# City of Albuquerque Stormwater Construction Site Inspection Report

ESC File No.	M15E054	Project Name:	Veterans Integration Center
NPDES Id. No.	NMR1005M1	Location:	2701 Mulberry St SE
8/2/2023	Owner	Contractor	
Operator	NM Veteran Integration Centers	Jaynes	
Contact name & title	Jerry Becker	Shad James	
e-mail	<a href="mailto:jerry@steomaticnm.com">jerry@steomaticnm.com</a>	<a href="mailto:shad.james@jaynescorp.com">shad.james@jaynescorp.com</a>	
Contact Phone #	505-833-7766	505-345-8591	
COA Inspector	Chancellor English	Start/End Time:	8:30am
Construction Phase:	Grading, foundation		
Type of Inspection:	Regular	Storm Event	Post Storm Event >0.25"
		311/Complaint	Follow Up
Weather at time of inspection?	Clear	Temperature: ~	85
Estimated date of last storm 0.25" or greater	5/22/2023

ESC-1

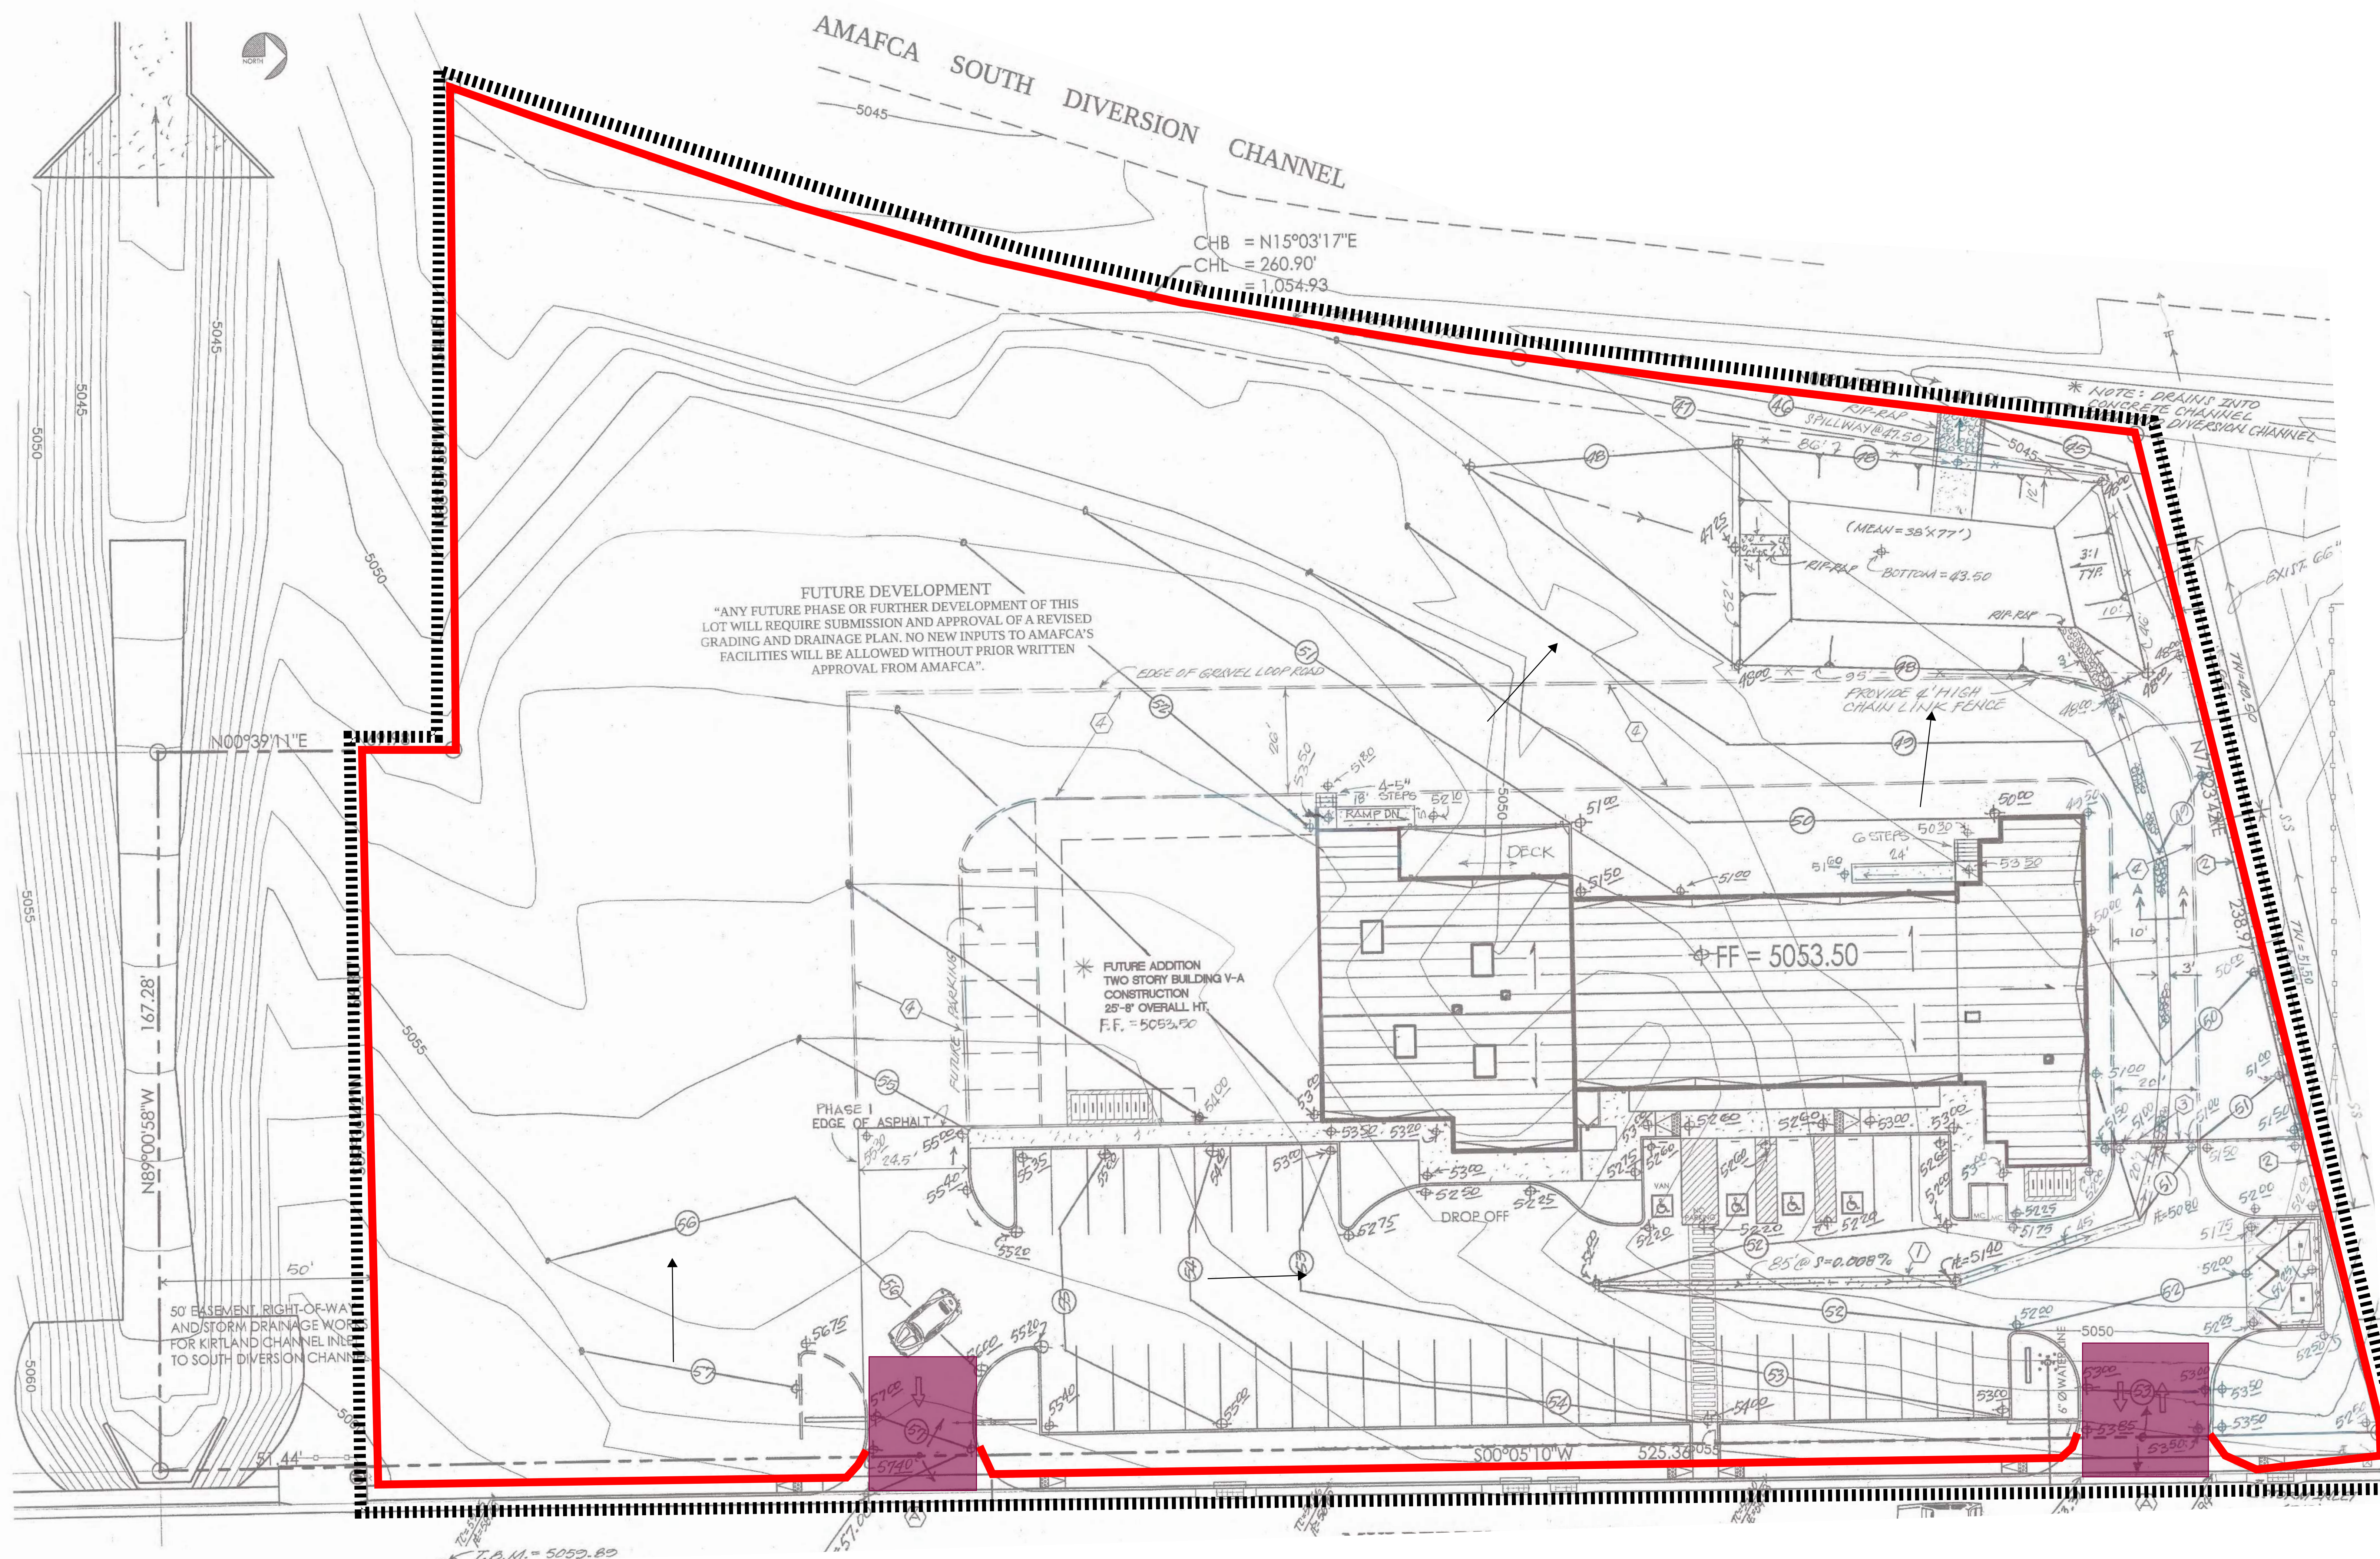
3	The permit coverage posting is missing the Owner's contact information. Required mitigation: CGP Part 1.5 requires you to post a sign or other notice of your permit coverage which must include a contact name and phone number (CGP Part 1.5.b).
4	BMP Repair/maintenance of silt fence at corner of the lot. Required mitigation: Ensure all stormwater controls are maintained and remain in effective operating conditions.

TYPICAL CONCRETE WASHOUT-BELOW GRADE

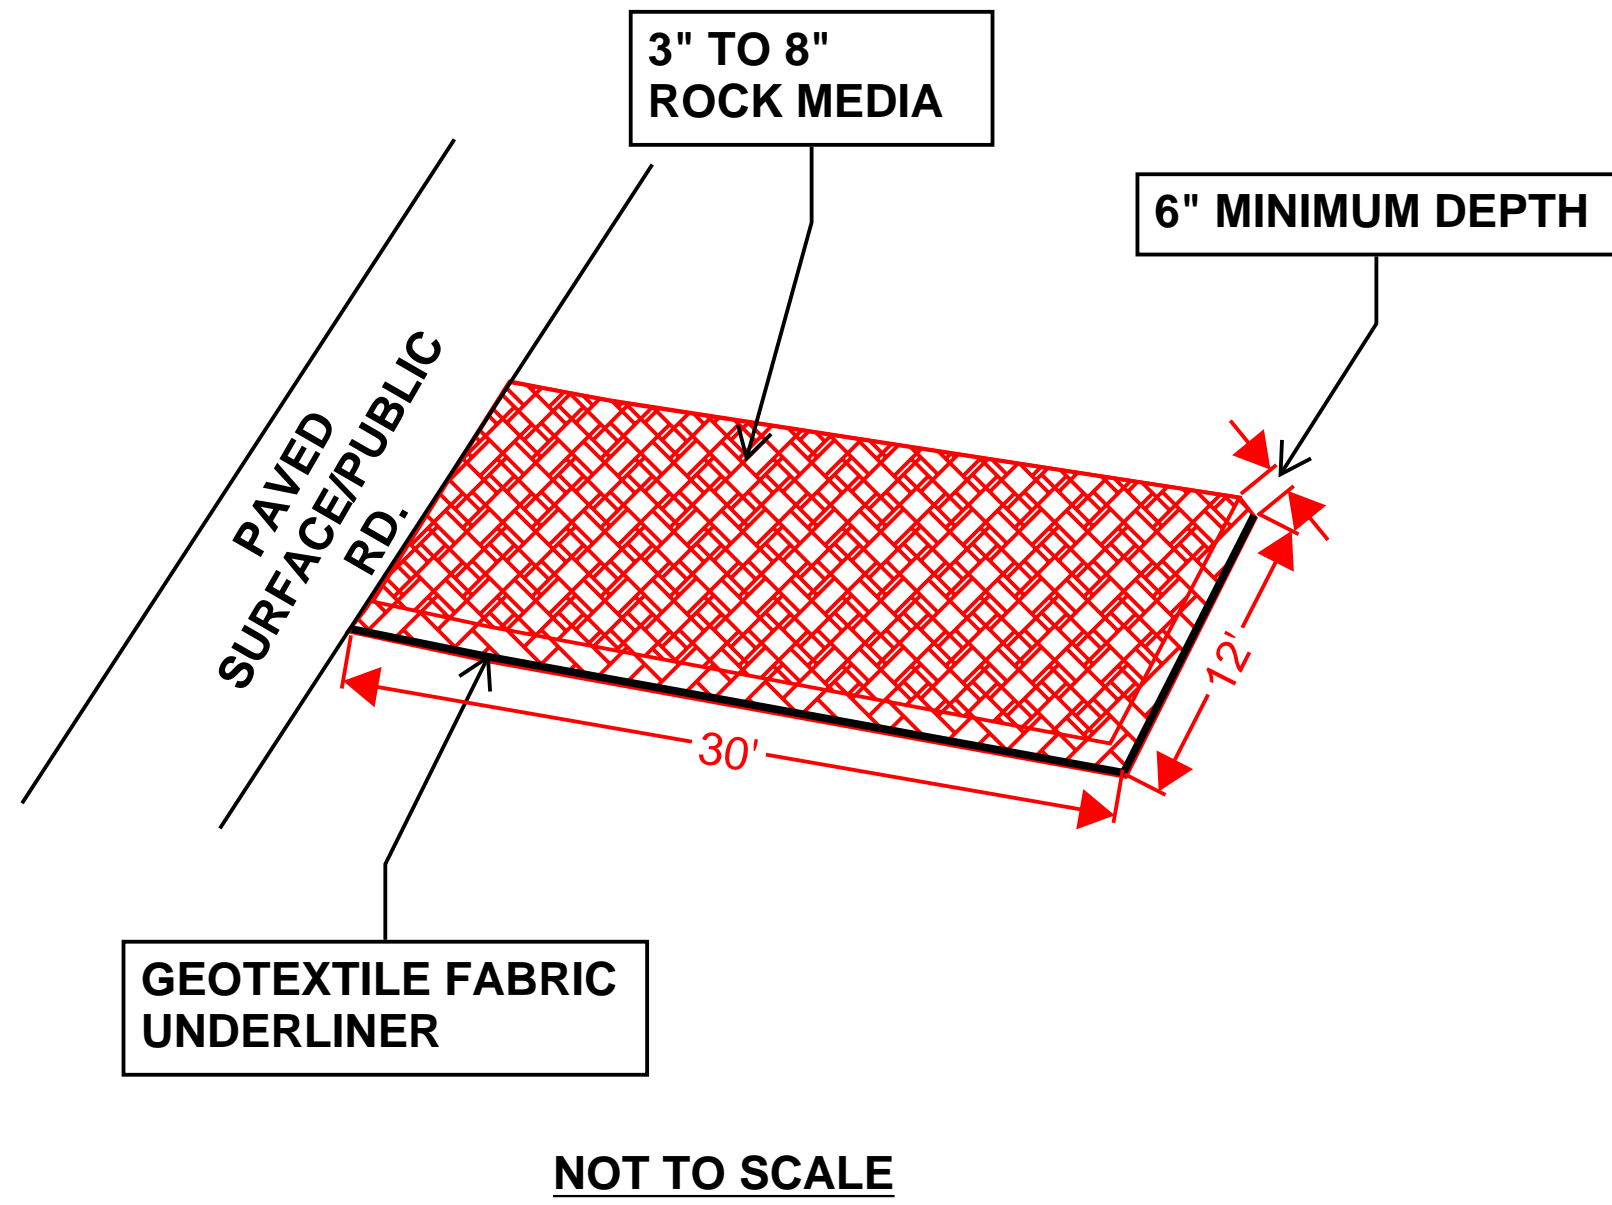
Item Number	Deficiency/ Corrective Action
1	Washout was found in multiple areas on bare soil. The container provided for contractors to use is unacceptable, it is not leak-proof or lined and is inconvenient to use with tall sides. Required mitigation: CGP Part 2.3.4 requires you to direct wash water into a leak-proof container or leak-proof and lined pit designed so no overflows can occur due to inadequate sizing or precipitation. Do not allow liquid wastes to be disposed of through infiltration or to otherwise be disposed of on the ground.
2	The SWPPP is incomplete and is not up-to-date. For both operators (Owner and Contractor), the SWPPP is missing both NOIs, certification signatures, and a delegation of authority. The SWPPP Map is not up-to-date, as it shows 2 construction entrances, and the self-inspection reports were unavailable. The Stormwater Team is missing a record of on-site training and a specific inspector. Stabilization plans also need to be included in the SWPPP. Required mitigation: Part 7.2 of the CGP lists the information that is required to be included in the SWPPP. This information includes the following: Identify the personnel (by name and position) that are part of the Stormwater Team, as well as their individual responsibilities, including which members are responsible for conducting inspections (CGP 7.2.2), SWPPP Certification in which your signatory must sign and date your SWPPP (CGP 7.2.10), A copy of your NOI (CGP 7.2.11.a), and a signed Delegation of Authority identifying a specific individual authorized to sign in lieu of the Operator (CGP Appendix G.11.2). You must modify your SWPPP, including the map, within 7 days whenever activities at your site are no longer accurately reflected in your SWPPP as per CGP 7.4.1.a. You must conduct a site inspection, at a minimum, once every 14 calendar days and within 24 hours of the occurrence of a storm event that produces 0.25 inches or more of rain within a 24 hour time period as per CGP 4.2. CGP Part 7.2.6.vii states that you must include stabilization measures in your SWPPP.
